Parramatta Leagues Club Hotel (SSD 8800) - 1 Eels Place, Parramatta, Notice of Exhibition

As delegate of the Heritage Council of NSW, I provide the following comments:

View looks towards the historic dairy building. The proposed design envelope for Western Sydney Stadium is shown dashed. PLC Hotel is not visible in this frame. (Source: HASSELL)

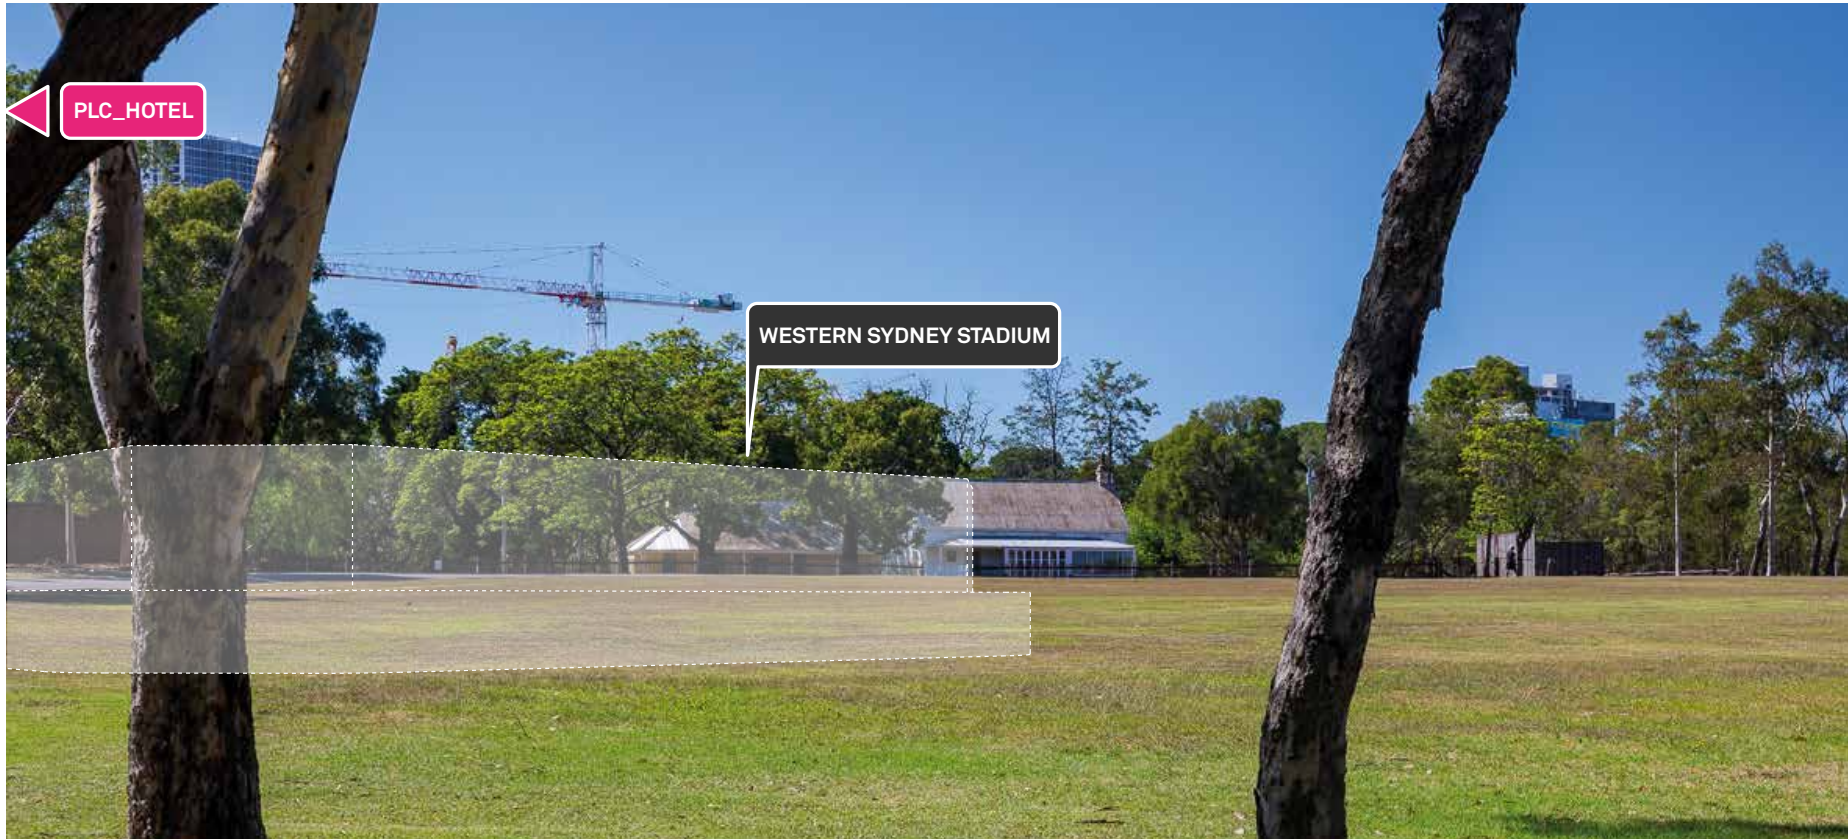
- The height of the tower is visually dominant and would introduce a prominent new feature to the skyline of North Parramatta if it proceeds in its current form. The height and scale of the proposal will significantly alter the character and skyline of this significant heritage precinct. It will have direct visual impacts on the above-mentioned items of State, National and World heritage significance. The proposal would interrupt views from the ridgeline and Crescent in Parramatta Park to the Hills District.

The Statement of Heritage and Visual Impact (SHaVI) prepared by Purcell (November 2018) concludes that the proposal does not present a significant impact on the views to, from and between the adjacent significant heritage items, nor that it has no significant impact on their heritage values. The Heritage Council does not agree with the conclusions of the proponent's assessment. We recommend that this assessment be peer reviewed by an independent heritage expert.

- For these reasons the Heritage Council recommends that the high-rise tower component of the current proposal be limited to a maximum height equal to the adjacent new Western Sydney Stadium. The stadium already represents an adverse incursion into the character and skyline of this significant heritage precinct. Given the stadium is already extant, it is recommended that this new development be limited in height to minimise additional adverse heritage impacts and to integrate the proposed new building with the surrounding area.
